Jeanie Bourke - Re: 7 Forest Ave, BP# 2014-00234 plan review comments

From: Jeanie Bourke
To: andreaahelm1325@gmail.com
Date: 3/6/2014 3:23 PM
Subject: Re: 7 Forest Ave, BP# 2014-00234 plan review comments

I have completed my review and have a few questions:

2.
1.
REVS:
CODE:
TOWN: Portland
DATE: 06-21-14
SCALE: AS NOTED
DESIGNED: SSA
DRAWN: SSA
TITLE: BUILDING FLOOR PLANS
FILE:
SHEET: A-1

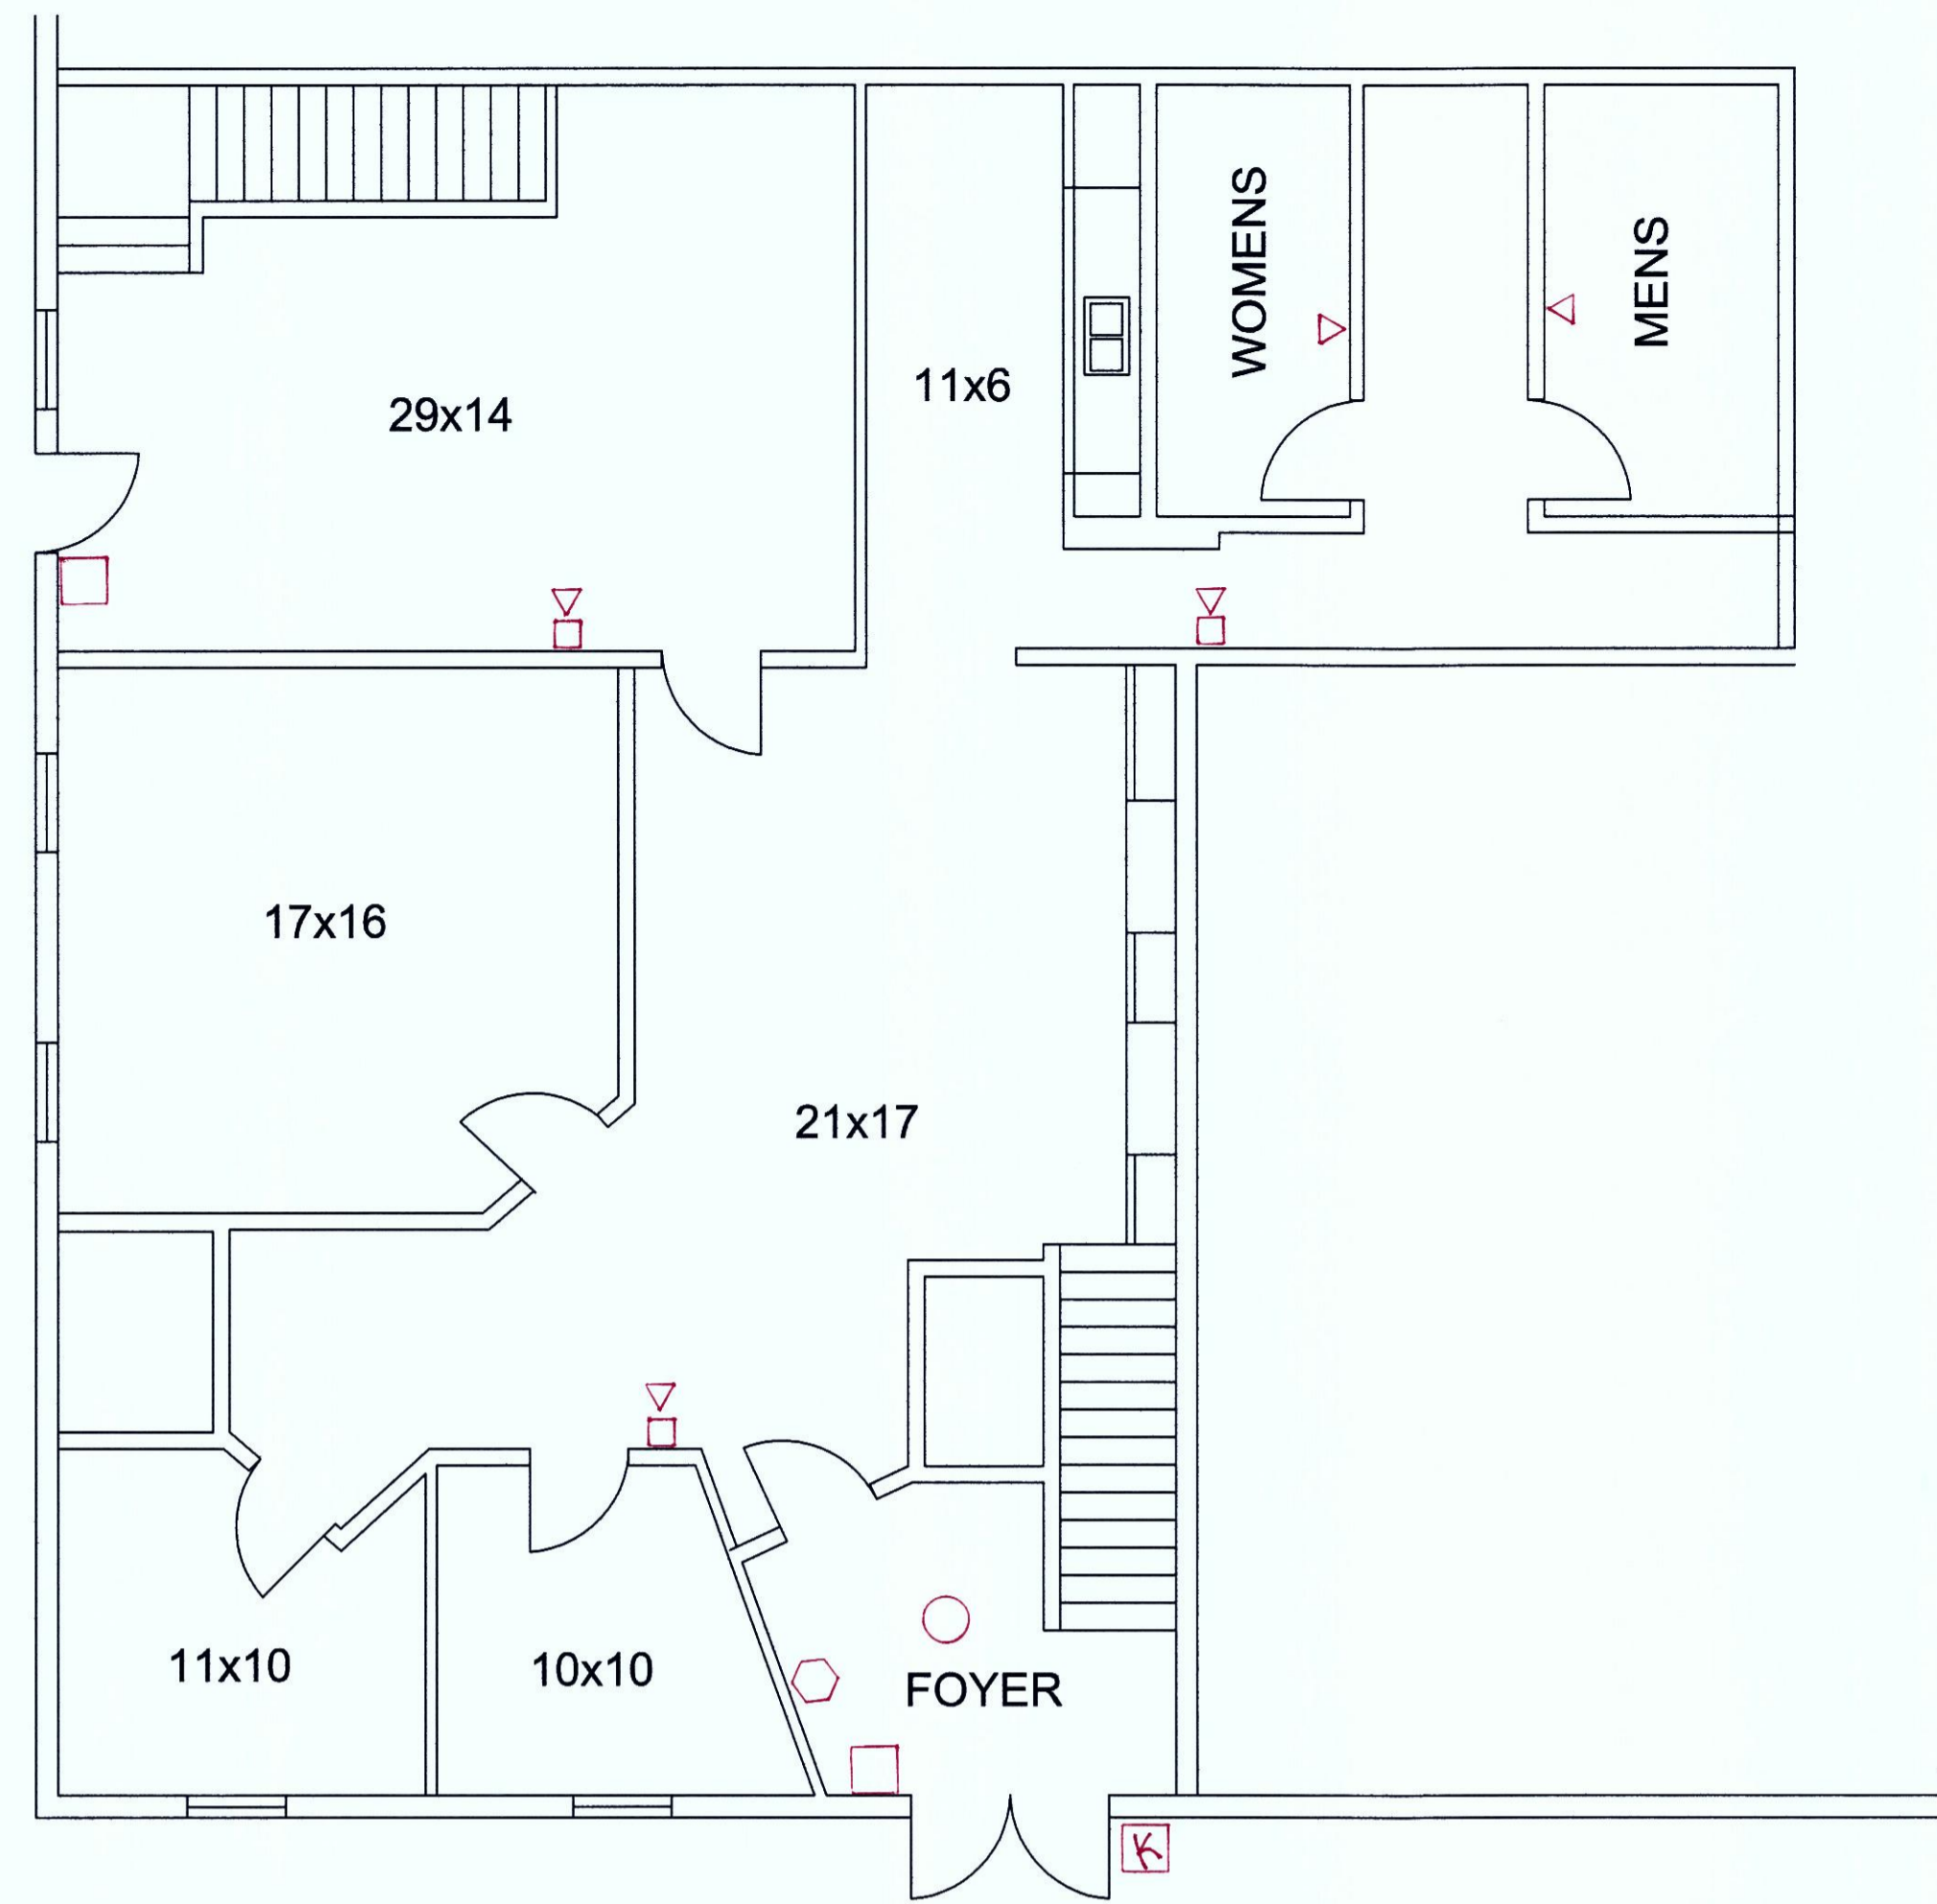
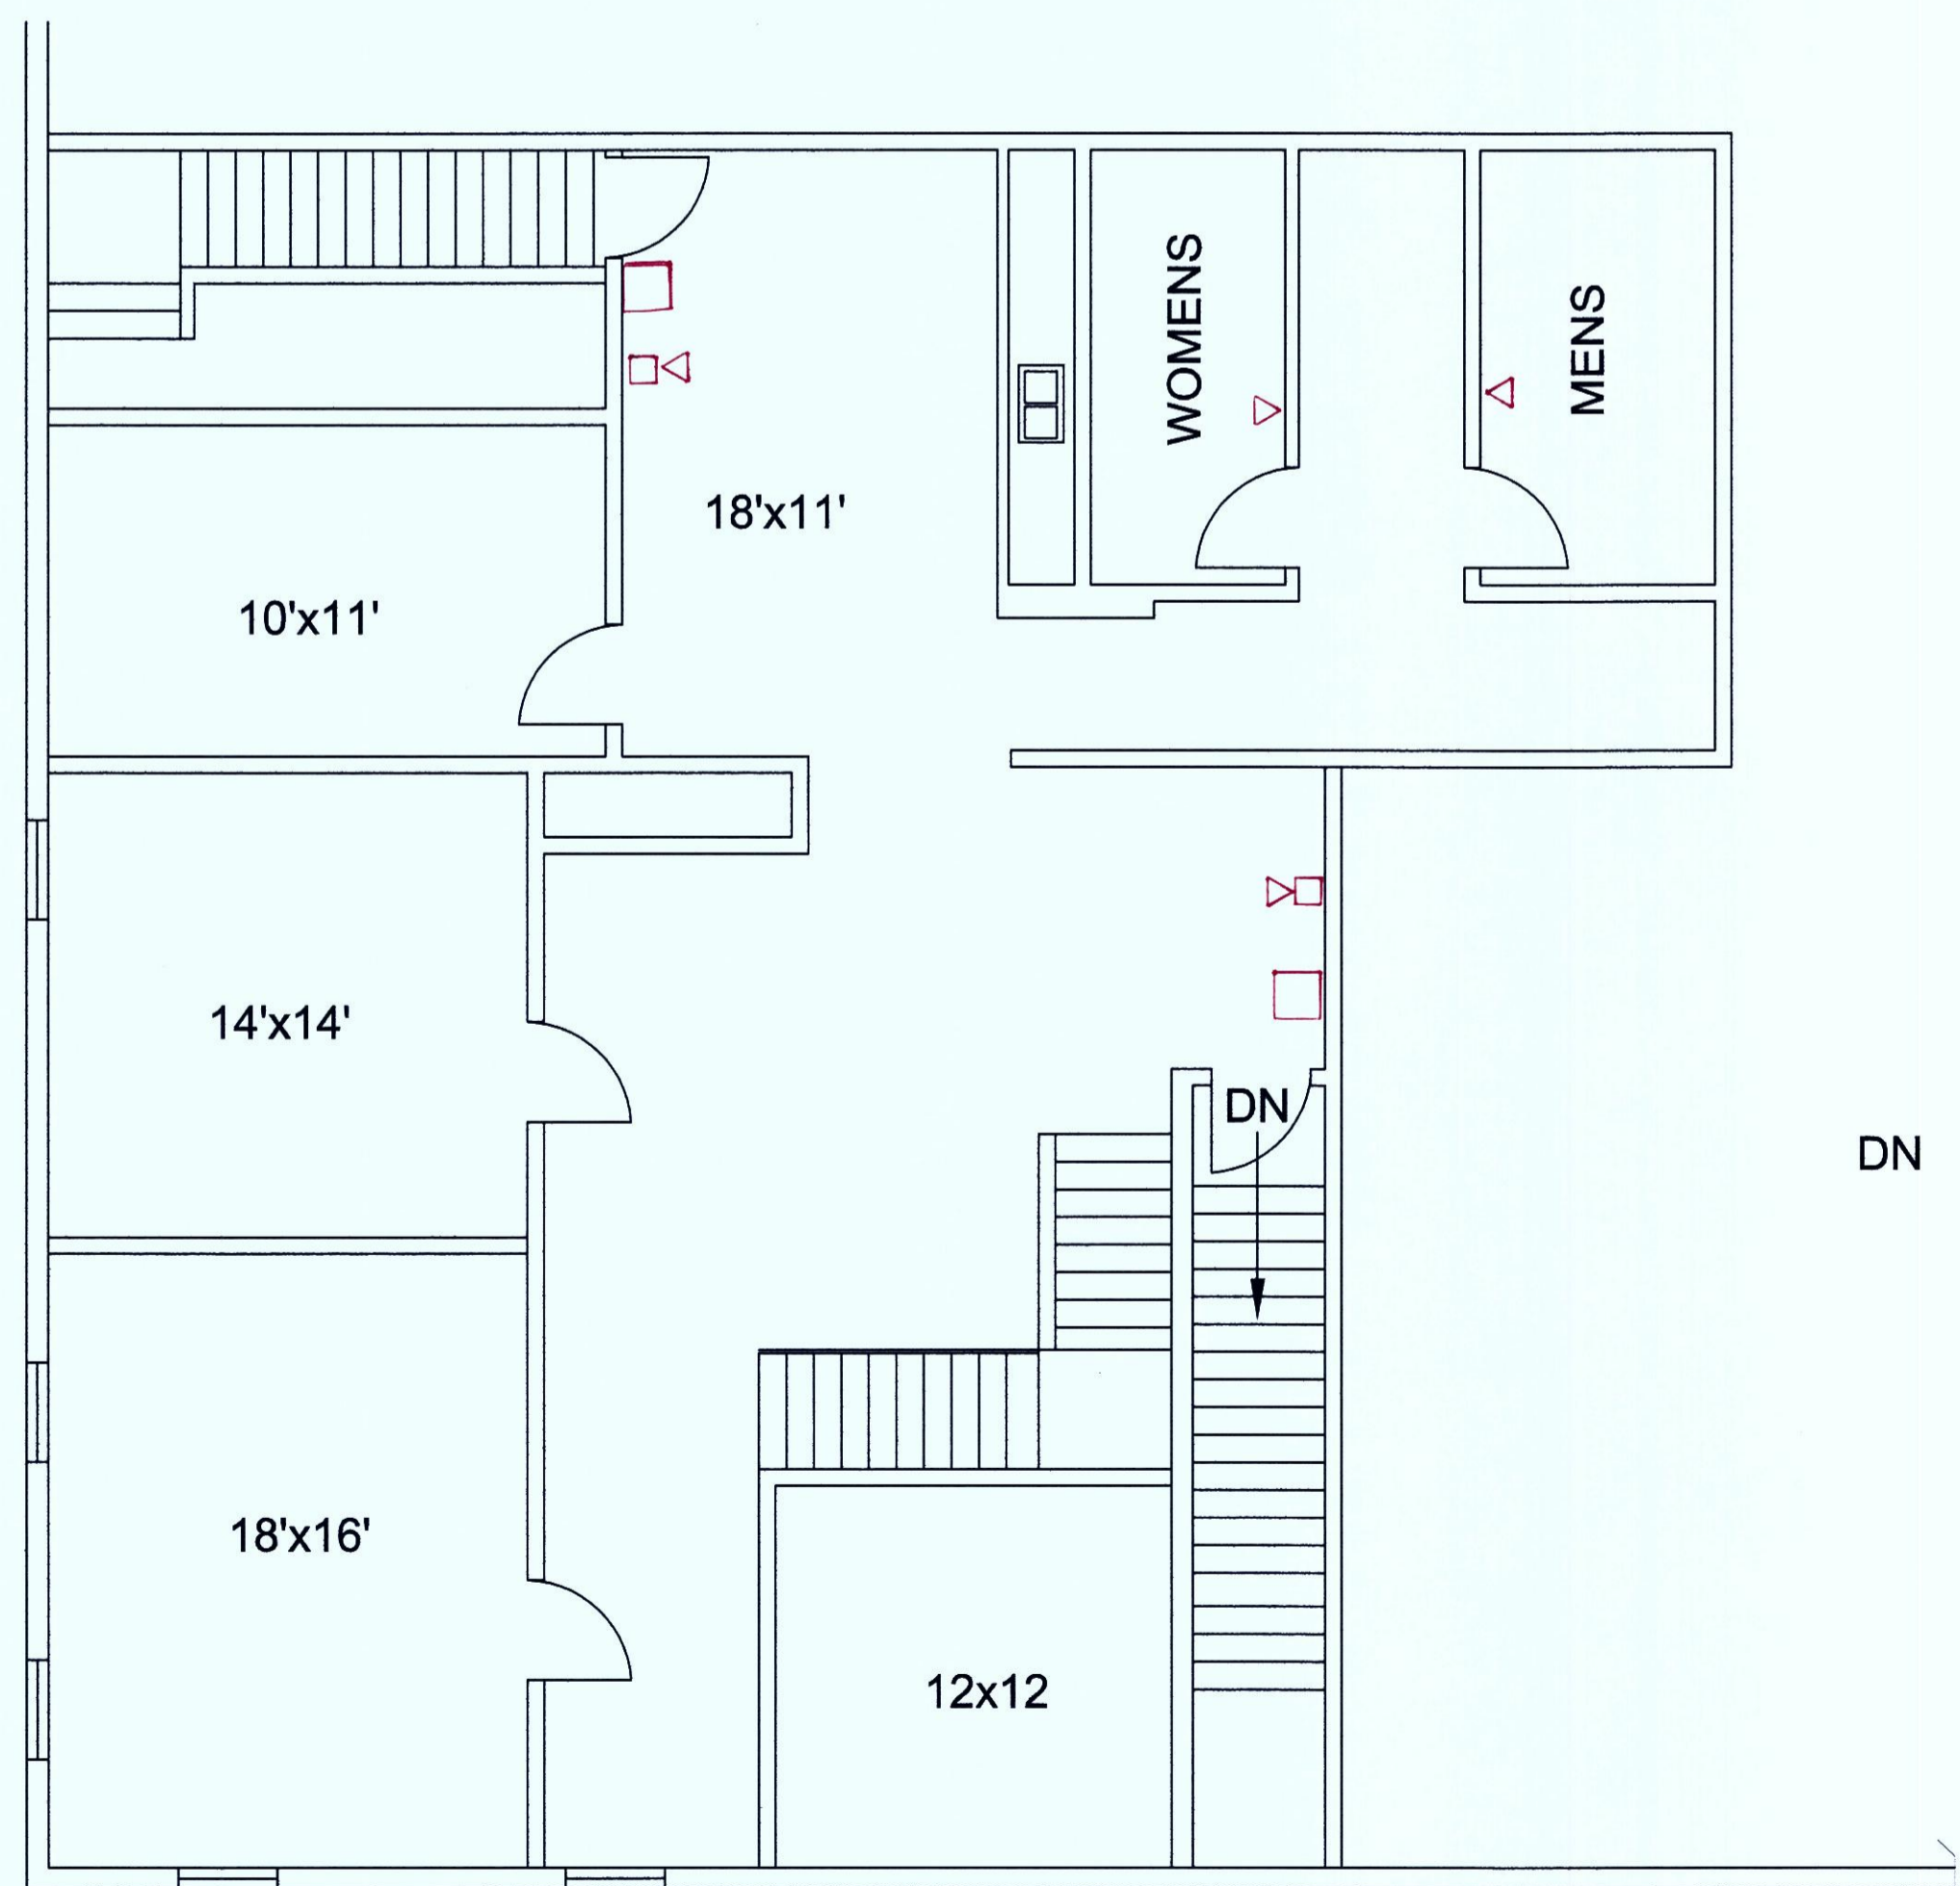
1. Is Suite B the only area of the gallery, 300 SF? Are the other Suites separate businesses? Does each suite have a door or are they all open? **Yes**

2. Do the stairs go directly to the outside on the first floor or do they enter into a common area? Is there a door at the stairs or is this open? **There is a door and stairs go to an entry/vestibule on the first floor and exit. There is also another stair from the 2nd floor not shown on these plans.**

3. I assume there are bathroom facilities, can you let me know where this/these are located? **There are bathrooms on the 2nd floor.**
